LAND TO THE SOUTH OF LITTLEHAMPTON ACADEMY

(Transport Assessment Addendum)

DOC: LTH-RGP-SW-XX-RP-Y-XX-6810 (P01)

TRANSPORT ASSESSMENT ADDENDUM

Highway adoption plan

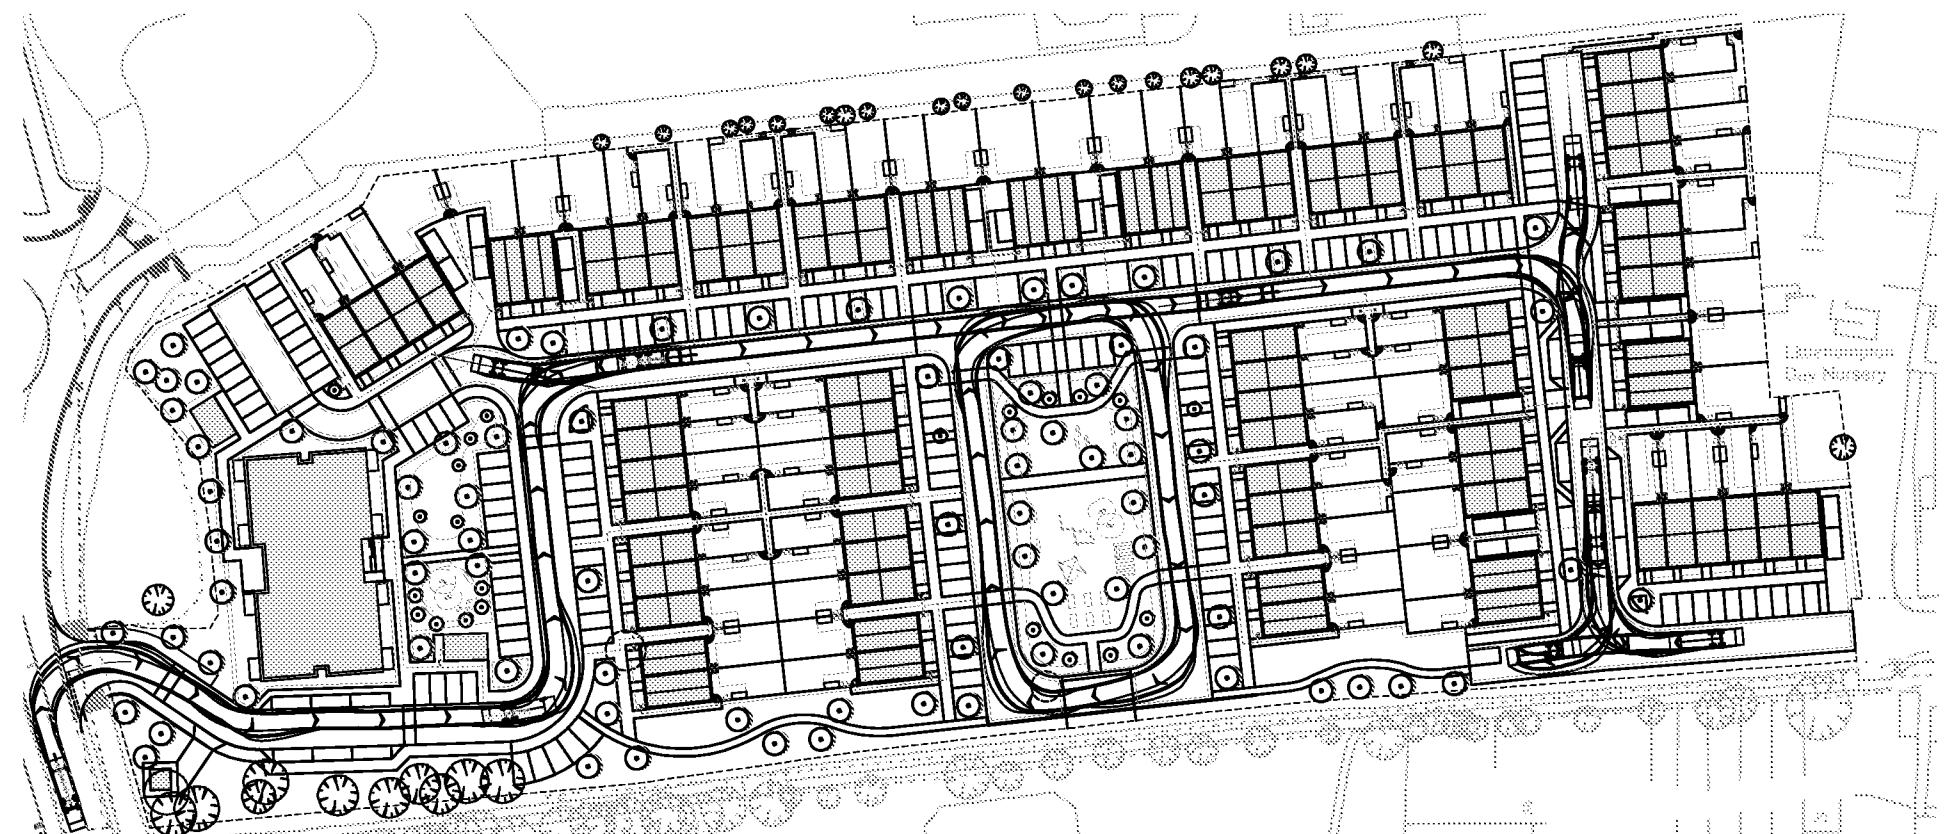
13. Whilst the adoption of the proposed access roads as public highway is not a material planning consideration, it would still be useful to understand the applicants intentions in respects of highway adoption. Where appropriate, comments are made regarding aspects of the design and highway adoption. It is accepted that some of these comments may not be applicable if the internal roads are being retained under private maintenance.

14. The internal roads are designed predominantly with footways segregated from the carriageway. Footways are generally 1.5 to 1.8 metres in width, with carriageways mainly 6 metres. Other than a few small areas, which are exclusively restricted to parking courts, there are no shared surfaces. Manoeuvring for a large refuse vehicle is also demonstrated. The principle of the carriageway and footway layout is considered to satisfy current guidance within Manual for Streets.

15. The only specific comment regarding the layout relates to specifics in terms of parking.
 - With those spaces running immediately adjacent to the carriageway edge, if the applicant's intention is to offer the roads for adoption but to allocate parking spaces to specific properties, a margin of at least 0.5 metre would be required between the carriageway edge and what will then have to be private parking spaces (as allocated parking cannot be provided within the public highway). This margin would be required to enable WSCC to maintain the highway edge.

- With respects to the above point, it should be noted that if the spaces are to be allocated/private, the preference would be for the footway (which is likely to be adoptable) to run adjacent to the carriageway edge (which would also be adoptable). The issue with the layout as shown is that this introduces the potential for private car parking spaces to be sandwiched between the adopted footway and carriageway. Again, comments are made on the basis that the layout will be adopted, which may not be the case.

- Car club parking spaces are also indicated. From the correspondence, the car club operator is willing to operate a single vehicle from the site initially, increasing to two vehicles if demand justifies it. It's recommended that only a single car club space is initially marked out. If the roads are to be offered for adoption, a traffic regulation order would be required to reserve the respective parking space for use the car club use.

- 5.1 Whilst the adoption of the proposed access roads is not a material planning consideration, WSCC has requested further information with respect to the intended adoption of the internal road network. Whilst the full extent of adoption has not been determined by the Applicant, the internal roads that may become adopted have been designed with consideration of adopted standards. Drawing 6800 attached hereto illustrates the extents of these streets that have been designed as such.

- 5.3 As illustrated on the attached drawing, the access road is provided with footways for the initial section of the site, before becoming an adopted shared surface. Footpaths would also be provided within the private (unadopted) areas, segregated from the shared surface, providing direct access to dwellings and through landscaped areas and play space. With respect to WSCC's specific comments, these are confirmed as follows:

- 2 All private car parking spaces running immediately adjacent to the carriageway edge would be provided with a minimum 0.5 metre margin, as illustrated on drawing 6800. A copy of the more detailed Landscape GA plans is also attached at Appendix F for reference;

- 2 All sections of footway to potentially be adopted is sited adjacent to the carriageway edge to avoid private spaces being 'sandwiched' between adopted areas. It is noted that the three spaces close to the entrance of the site are proposed for adoption, which would include the car club spaces to ensure that they can be controlled and maintained by the Highway Authority, in liaison with the car club operator, in perpetuity;

- 2 As confirmed by WSCC, a single car club space would be marked out with a traffic regulation order to be put in place on to reserve the additional space for the use by a car club in the future. Full details of the car club spaces would be provided through the full Travel Plan.
